Our ref: RA/2016/135680/01-L01
Your ref: 2016/93147
Date: 16 November 2016

**OUTLINE APPLICATION FOR ERECTION OF RESIDENTIAL DEVELOPMENT.
444 BRADFORD ROAD, BATLEY, WF17 5LW**

Environment Agency position

**Appendix A: - Existing
Ground Levels
and Proposed
Layout Plan**

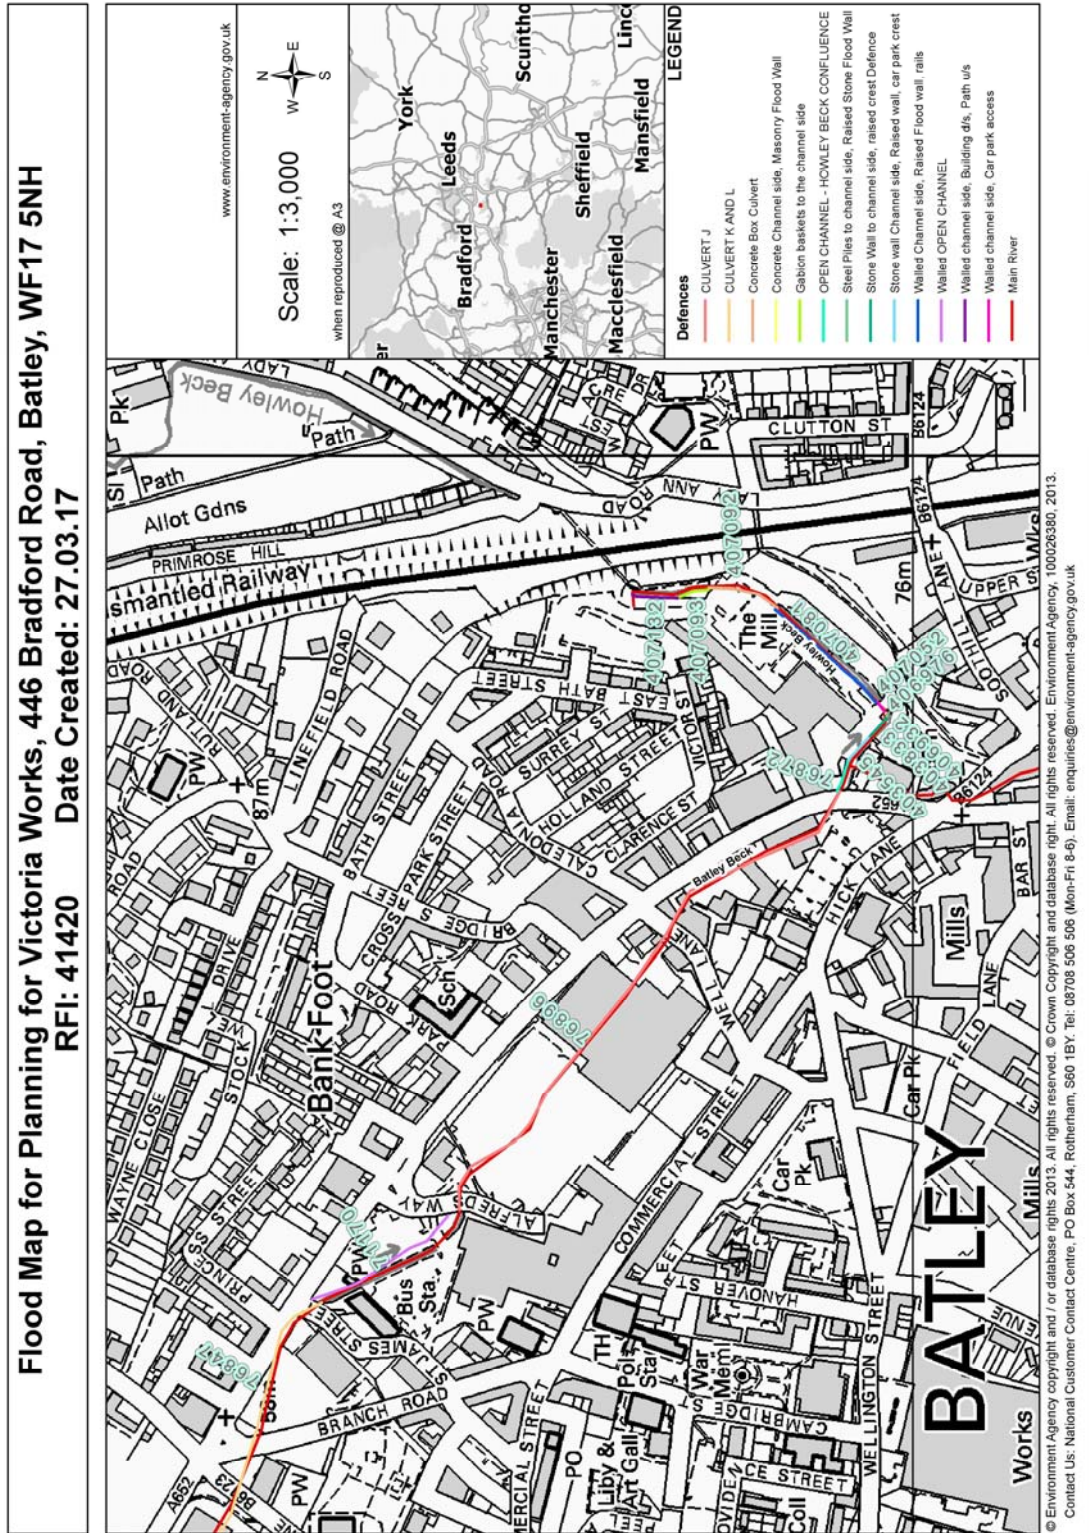
In particular, the submitted FRA fails to reference the latest relevant modelling data available for Batley Beck which has been made available since the FRA was first produced in 2010. As such, the minimum finished floor levels have not been properly assessed and may not provide suitable mitigation for the development.

For a residential development, a finished floor level of 600mm plus 1% annual probability flood level, plus climate change should be established. The latest climate change guidance needs to be considered. More information on the latest climate change guidance can be found here: <https://www.gov.uk/guidance/flood-risk-assessments-climate-change-allowances>

The applicant can overcome our objection by submitting an FRA and proposed layout plan which covers the deficiencies highlighted above and demonstrates that the development will not increase risk elsewhere and where possible reduces flood risk overall. If this cannot be achieved we are likely to maintain our objection to the application. Production of an FRA will not in itself result in the removal of an objection.
